**KIRKLEES METROPOLITAN COUNCIL
INVESTMENT & REGENERATION SERVICE**

DELEGATED DECISION TO DETERMINE PLANNING APPLICATIONS

Reference No:	2025/62/92457/E
Site Address:	50, Parker Road, Thornhill Lees, Dewsbury, WF12 0AP
Description:	Erection of outbuilding
Recommending Officer:	Jennifer Booth

DECISION - REFUSE

Revisions	Date	Aug 2025	Planning Application for:
			Rear Extension 50 Furker Road, Thornhill Lees, Dewes.
			Drawing Title: Existing and Proposed Plans and Elevations
			Drawing No: S01
			Rev B

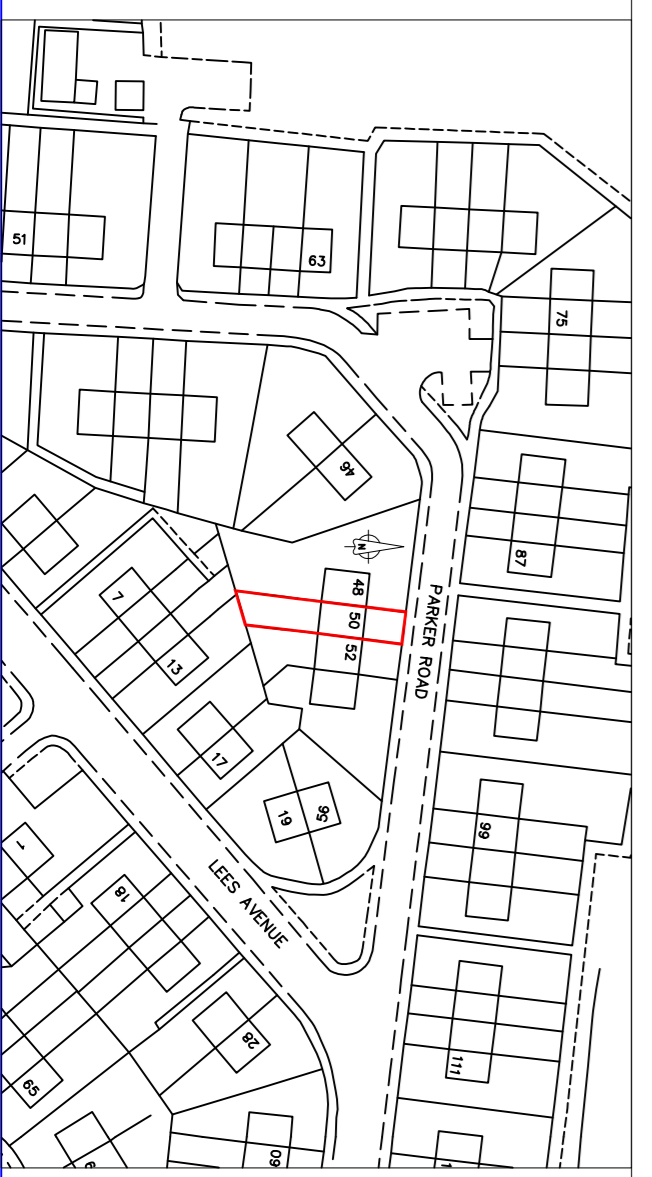
The outbuilding to the rear of the property raises concerns regarding visual amenity and overdevelopment. The site has already been extended with both single and two-storey rear additions, and the addition of a further outbuilding results in a disproportionate and excessive form of development. The

materials used, particularly the rendered finish, are out of keeping with the brick-built dwelling and surrounding properties, leading to a lack of visual harmony. Although outbuildings exist in the area, none exhibit such a linear and visually dominant relationship with an already extended main house. The proposal is therefore considered unacceptable due to the cumulative impact of extensions and additions, disproportionate scale, and poor integration with the existing built form.

Having taken the above into account, the outbuilding causes significant harm to the visual amenity of both the host dwelling and the wider street scene. As such, the development fails to comply with Policy LP24 of the Kirklees Local Plan (a) in terms of form, scale and layout, and (c) as it does not constitute a subservient addition. It also conflicts with KDP 1 & 2 of the House Extensions & Alterations SPD and the aims of Chapter 12 of the National Planning Policy Framework.

The outbuilding has been built along the shared boundary with a wall height in excess of 3m. This has a significant overbearing impact on the neighbour's amenity space. Furthermore, the position of the outbuilding to the west of the neighbour results in overshadowing in the afternoon along the entirety of the neighbour's garden. Although there are no openings which could result in any

loss of privacy, the harm in terms of the overbearing and overshadowing impacts are significant.

With regards to the impact on the adjoining 52 Parker Road, the scheme has been considered in terms of KDP3 – privacy, KDP5 – overshadowing and KDP 6 – overbearing impact of the House Extensions & Alterations SPD, policy LP24 of the KLP c) in term of minimising impact on neighbouring occupiers and advice within chapter 12 of the NPPF and the proposals are considered to be unacceptable.
